Application number: 2026/90343	
What is the application for?:	Erection of two detached dwellings with associated works
Address of the site or building:	54, Victoria Street, Clayton West, Huddersfield, HD8 9NW
Postcode:	WF14 8HE

### User comments

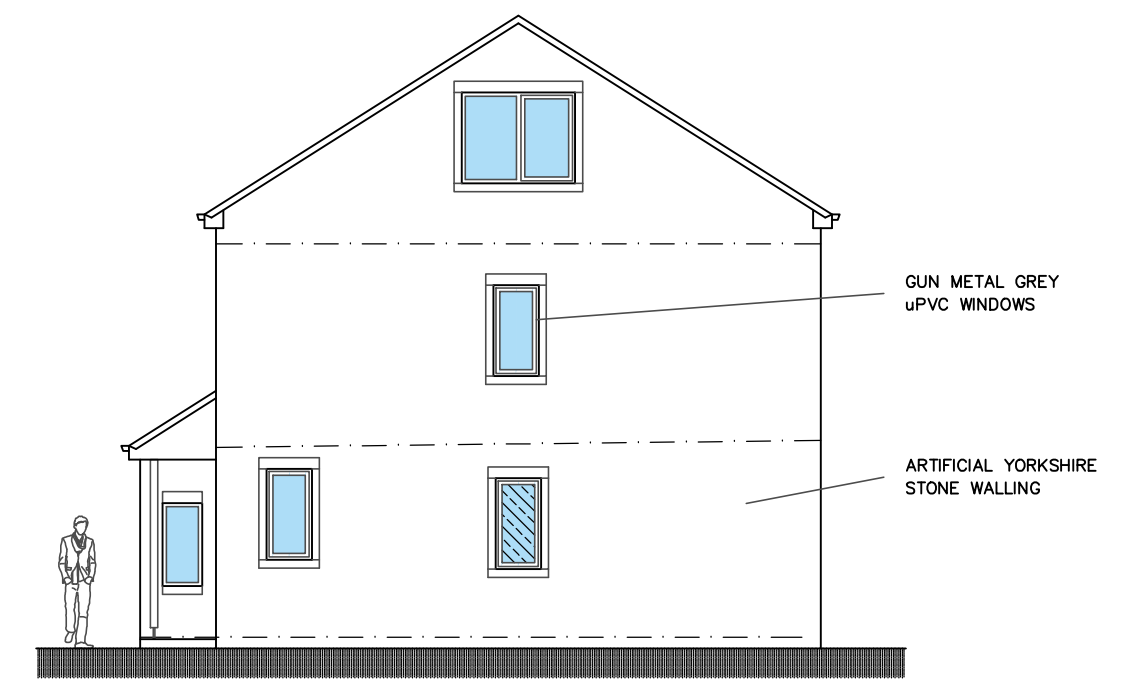
Type of comment: An objection	
Do you wish your comments to be published on the website anonymously?	No
My concerns and objections are regarding the height of the proposed dwellings. The dwellings are proposed to be three storeys high, these are sat at the top of a relatively steep road and will not only make the junction more difficult to navigate, they will completely dominate the properties around.
